**Consultation Response from Mike Hibbert,
KC Waste Strategy(Refuse & Recycling)**

2023/93495 Land rear of, Yorkshire House, South Street, Dewsbury, WF13 1JT

Erection of hotel (within a Conservation Area)

Responding Ref: WPN 24-014

DRAWING TITLE
VEHICLE TRACKING

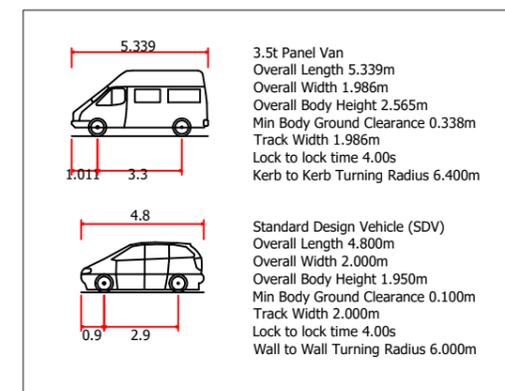
- Suitable site access and manoeuvrability space for a Refuse Collection Vehicle is vital. This obligation will exist in perpetuity on any development and as such will be a critical consideration in the layout of the site.
- School Street has a One Way/ uni-directional traffic flow. Unless active measures are taken parked vehicles may prevent collection or cause collection vehicles to block the carriageway. It is not clear if the intention is for an RCV to reverse into the site from School Street to the bin store. Reversing of RCV's presents an established health and

safety risk. Any proposals should consider the potential impact on pedestrians and motorists when waste collection is occurring at the site.

Drawing Number:
21-055-50B

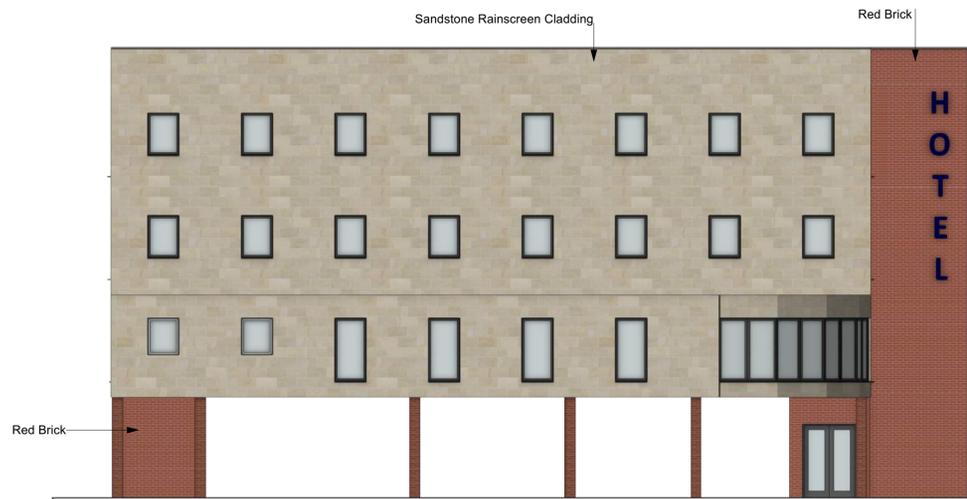
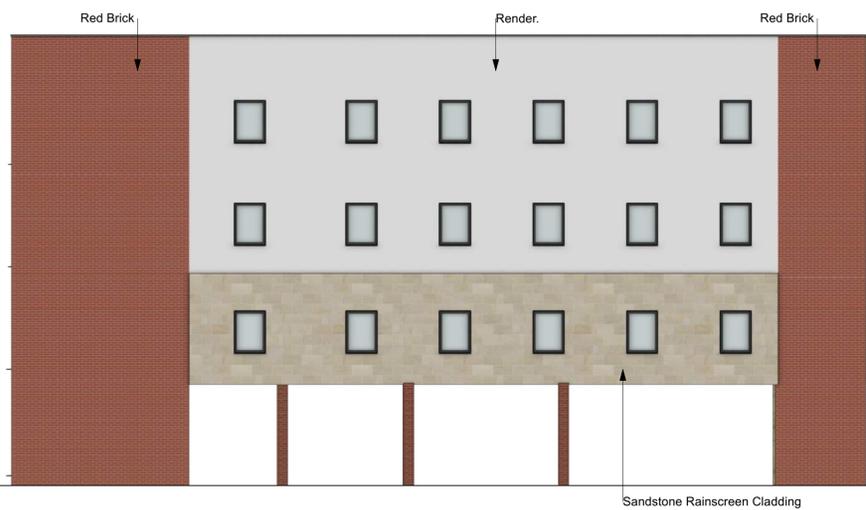
- The applicant has submitted Site Plan and Elevations As proposed Drawing No 21-055-50B dated 05/06/24 that shows the bin store located adjacent to the access road at the northern end of the site.

- The bin store is shown on the plan has dimensions of 4.85m by 2.05m with a gate opening of 1.84m. There are three wheeliebins shown in the store (approximately 1210mm x 830mm). Current Wheeliebin sizes are for 660 ltrs 1360x770 (floor space 1560x970) and for 1100ltrs 1375x990 (floor space 1575x1190). The overall bin store size is potentially adequate to accommodate the waste generated on site particularly if the frequency of collection is weekly.

- The waste store should be secure to prevent theft, unauthorised use/ fly tipping or rough sleeping. If the doors to the bin store are to have a keypad to secure access these details will be required by the collection staff.

- Waste storage presents a fire risk. When undertaking a fire risk assessment for the premises the location of the bin store should be carefully considered and the store may need relocating away from the adjacent premises. The construction specification for the store should follow BS5906:2005, Building Regs 2010 Part H6 and CFPA-E Guideline No 7:2022 F.

- Additional information is required detailing design of the waste storage compound including screening, surfacing and security.
- The route between the store and bin collection point needs to be a hard smooth surface), have a drop kerb or absence of steps and a maximum gradient of 1:12. Guidance indicates that the maximum drag out distance for a full 1100ltr wheeliebin should be in the region of 15m. Compliance with this drag out limit should be should achievable on this site.
